Application number: 2025/91370	
What is the application for?:	Demolition of existing dwelling and erection of 50 dwellings with associated acc
Address of the site or building:	Land at, Gynn Lane, Honley, Holmfirth, HD9 6LF
Postcode:

Type of comment: A general comment	
Do you wish your comments to be published on the website anonymously?	<input checked="" type="checkbox"/> Yes
<p>The PEAR contained sensitive information in relation to badgers. The page came with a warning stating that it should be removed before been made public, and this did not occur.</p> <p>The BNG metric has not been provided for scrutiny and nor have the condition assessment sheets.</p> <p>A BNG assessment had been carried out initially on the to determine the baseline, and a further updated assessment with fixed layout proposals.</p> <p>However, the onsite baseline values have changed between the two assessments with no explanation and no obvious changes in the red line. Area habitats have increased from 6.96 to 7.11 units, and watercourse units have decreased from 0.77 to 0.65 units. While the change in area is fairly insignificant (2% increase), the change in watercourse units is significant (16% decrease).

CULVERT LOCATION PLAN SCALE 1:200

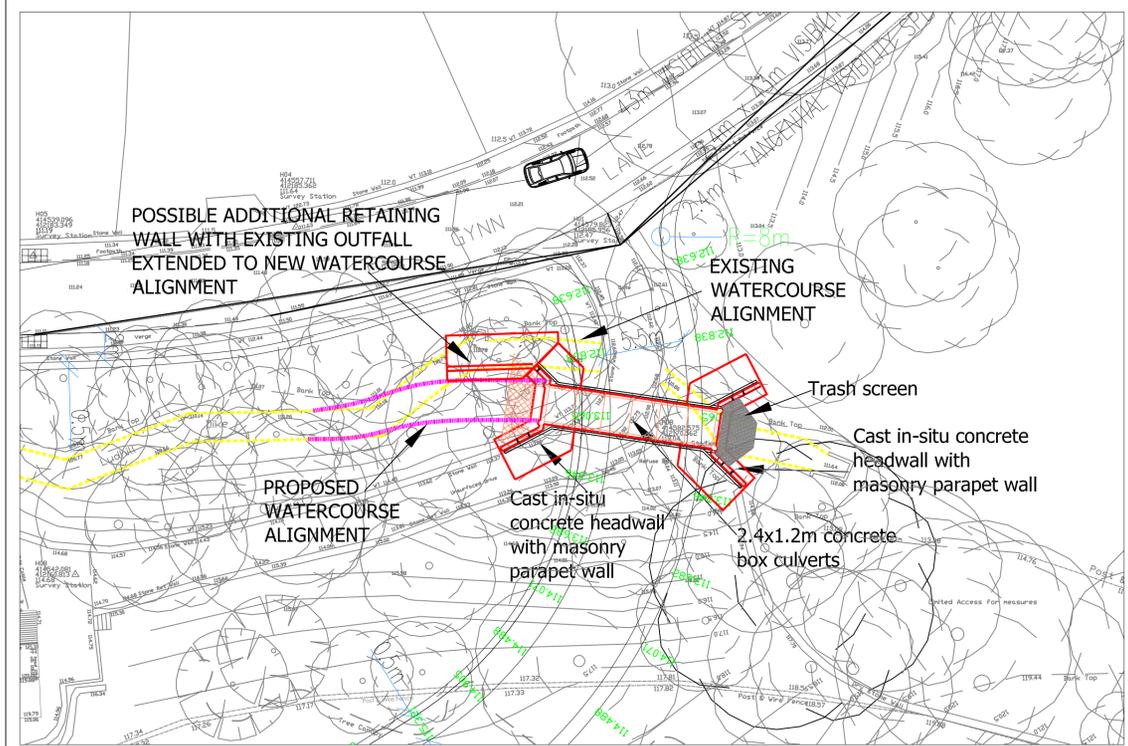
A section of the watercourse will be culverted further beneath the access to the site, a new outfall pipe and realignment of the channel. This is detailed further in the drainage strategy. This has not been considered within the watercourse metric calculations as the watercourse is indicated as retained, when it should in fact be considered as lost, and a culvert created.

As such, the watercourse unit losses are likely higher than that stated within the BNG assessment.

Furthermore, the culvert / outfall headwall along the north bank is not within the red line. All development should be within the red line, as such these areas should be removed from the blue line and put into the red line. In addition, consideration on the impacts to the woodland should be considered within these areas, such as the need to clear vegetation (e.g. T1-T5, T7) to gain access to the watercourse and construct the culvert / headwall.
